PR-2024-010329

**MINOR_PLT-2025-00014 – PRELIMINARY/FINAL PLAT
SKETCH PLAT 5-15-24 (DFT)**

TIM ALDRICH agent for **LAS VENTANAS NM, INC** requests the aforementioned action(s) for all or a portion of: **LOT/TRACT 97B, MAP 34 TR 97B** zoned **R-A**, located at **2611 Rio Grande Blvd NW** containing approximately **0.9042** acre(s). **(G-12)**

REQUEST: Subdivide 1 existing tract into 3 tracts. Grant private access and public utility easements. Grant ABCWUA public water and sanitary sewer easement. The new tract adjacent to Rio Grande will contain the existing residence.

**Plat for
Tracts 97-B-1 thru 97-B-3,
MRGCD Map No. 34
Being Comprised of
Tract 97-B, MRGCD Map No. 34
City of Albuquerque
Bernalillo County, New Mexico
May 2024**

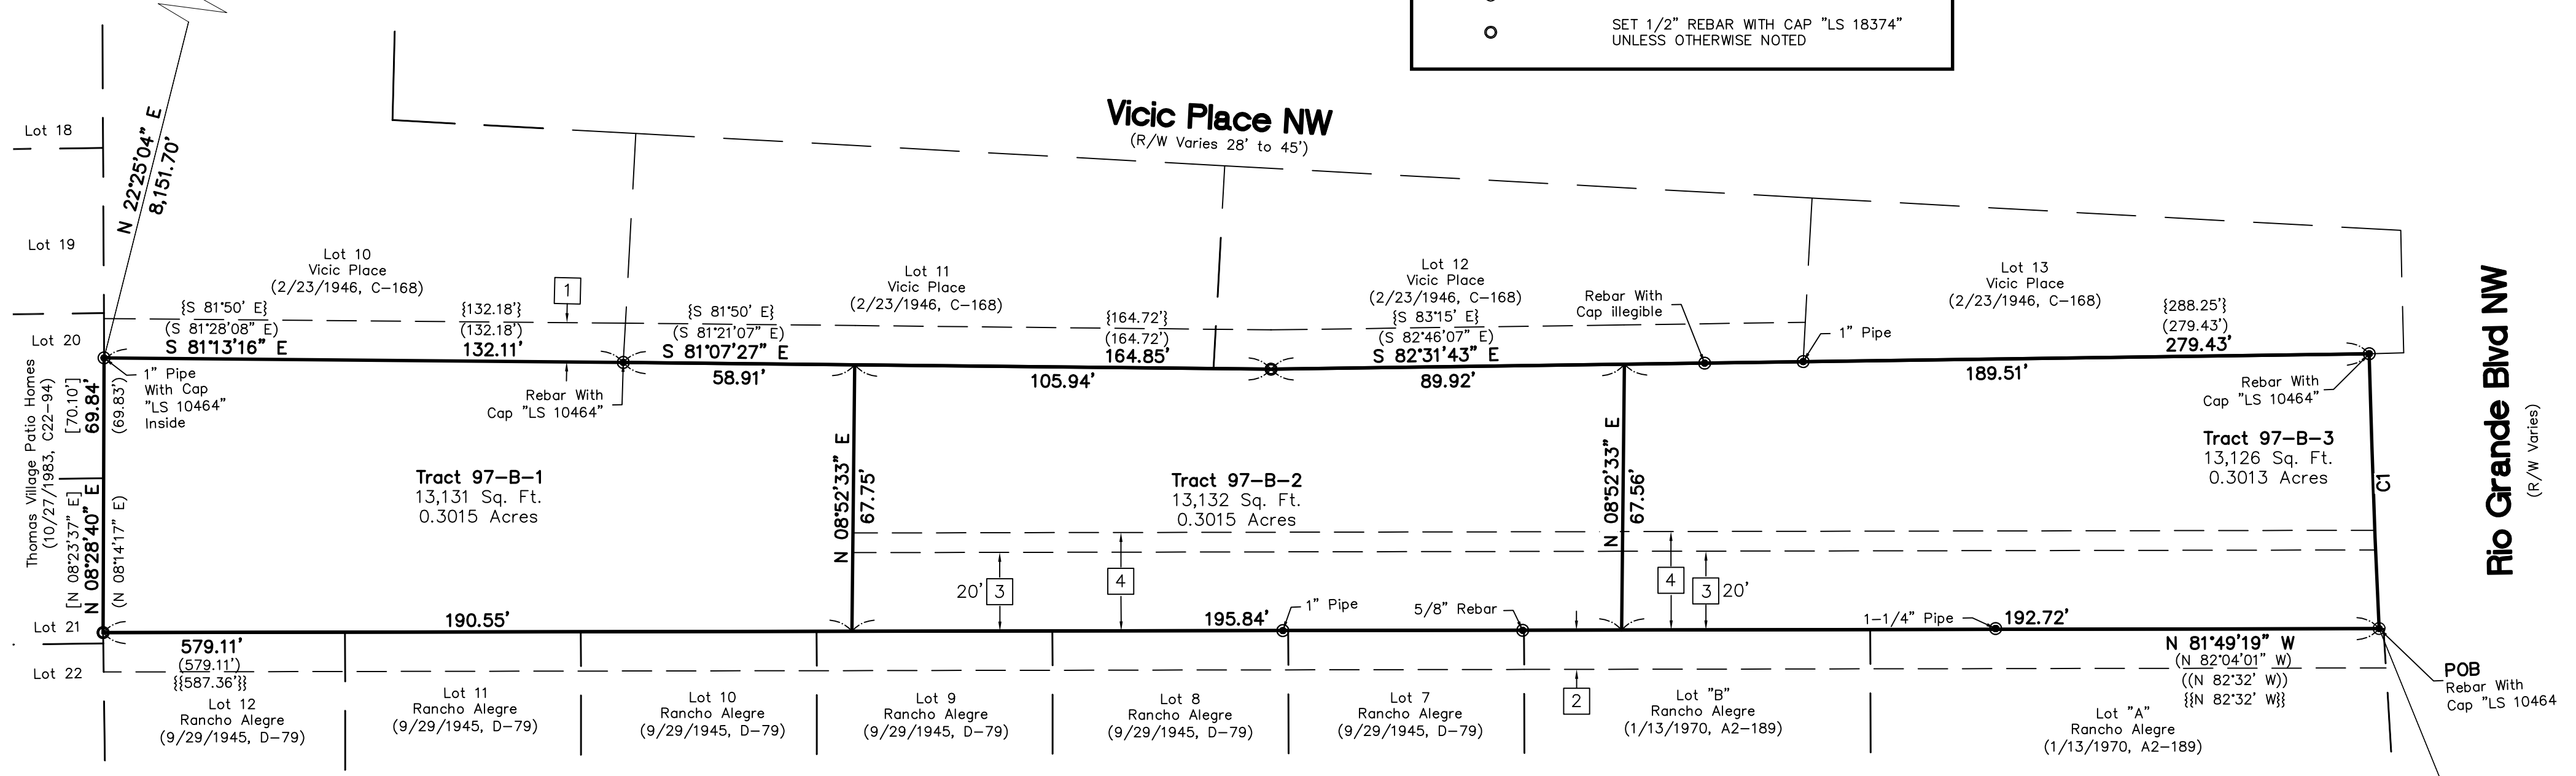
- 1. Zoned R-A and requires 75 ft lot width a variance is required.*
- 2. A variance to the required 10 ft side yard setback if the buildings are attached. Are the buildings attached or are they free standing to determine if a deviations may be applied.*
- 3. Code Enforcement has no further comments or objections at this time.*

**Site Sketch for
Tracts 97-B-1 thru 97-B-3,
MRGCD Map No. 34
Being Comprised of
Tract 97-B, MRGCD Map No. 34
City of Albuquerque
Bernalillo County, New Mexico
April 2024**

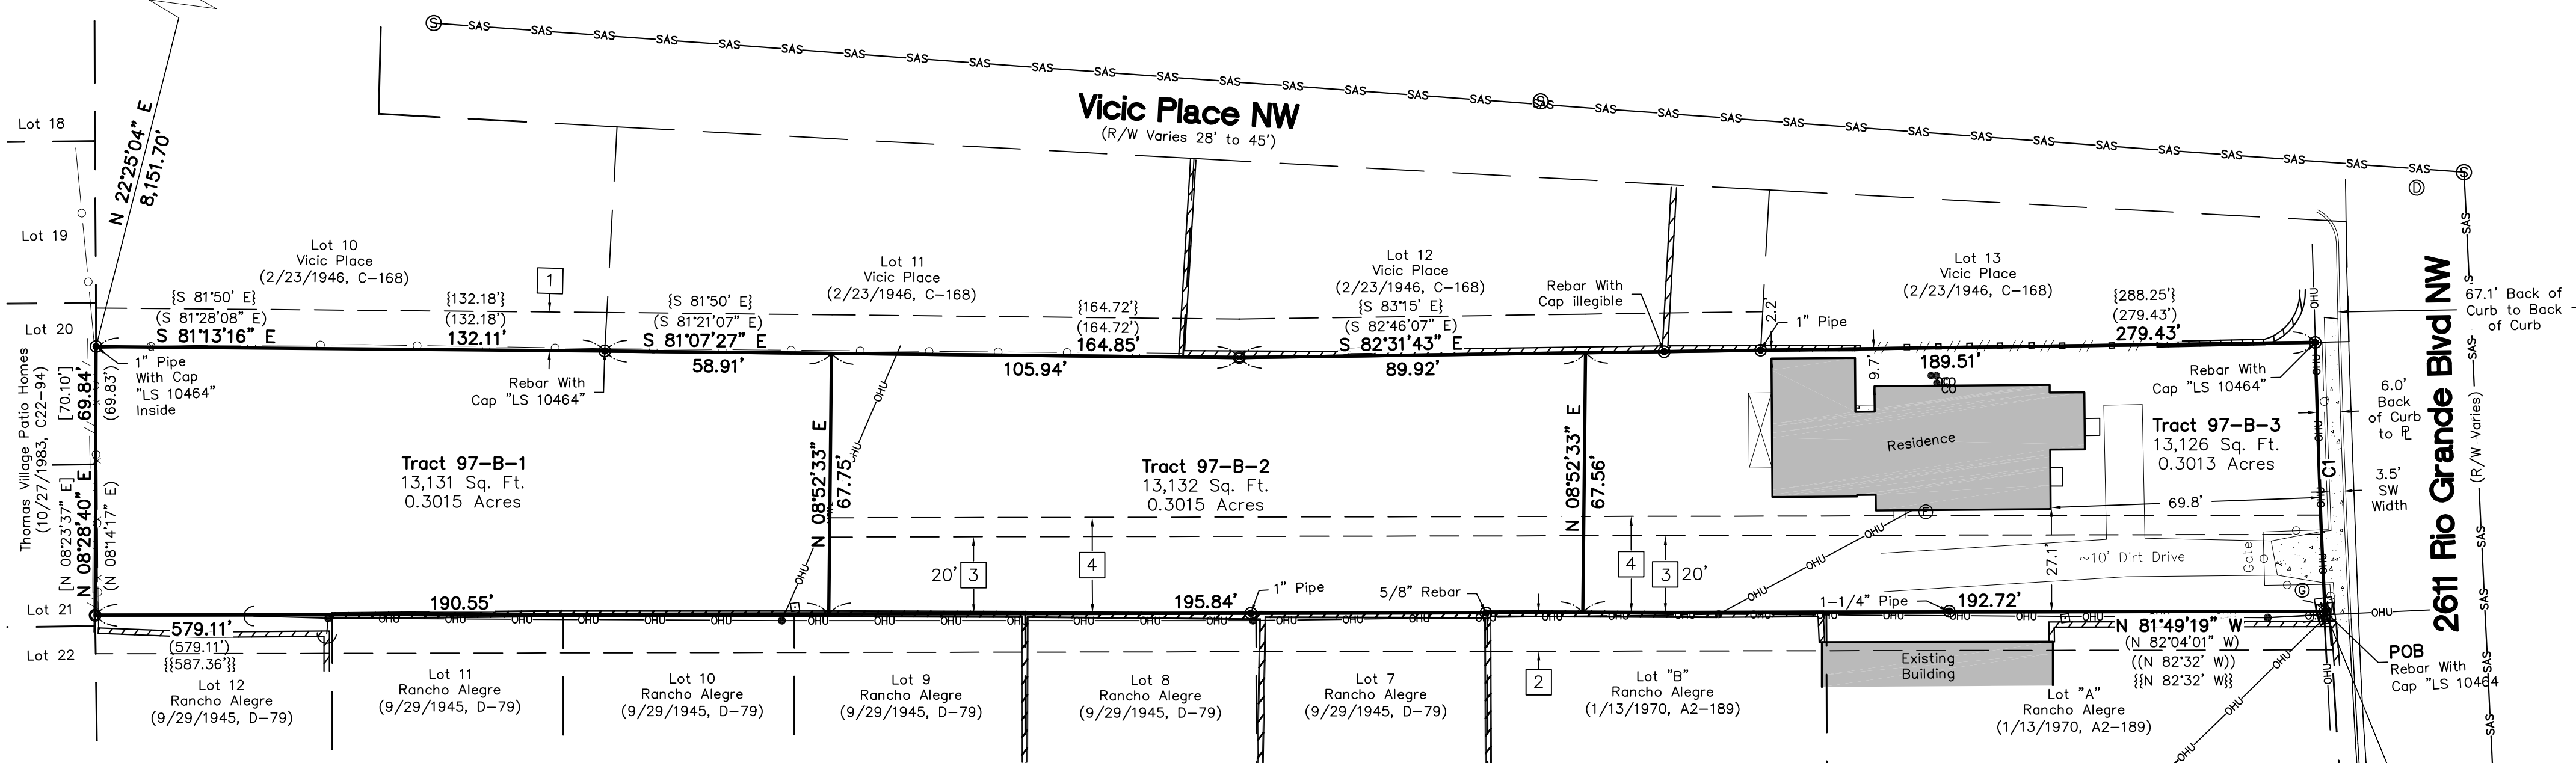
1. Rio Grande is a Minor Arterial and requires 6' sidewalk with a 5' to 6' landscape buffer. You are only showing 4' sidewalk and 3' buffer.
2. The access easement needs to be a minimum of 22' wide for access to 3 properties. You are only showing 20'.
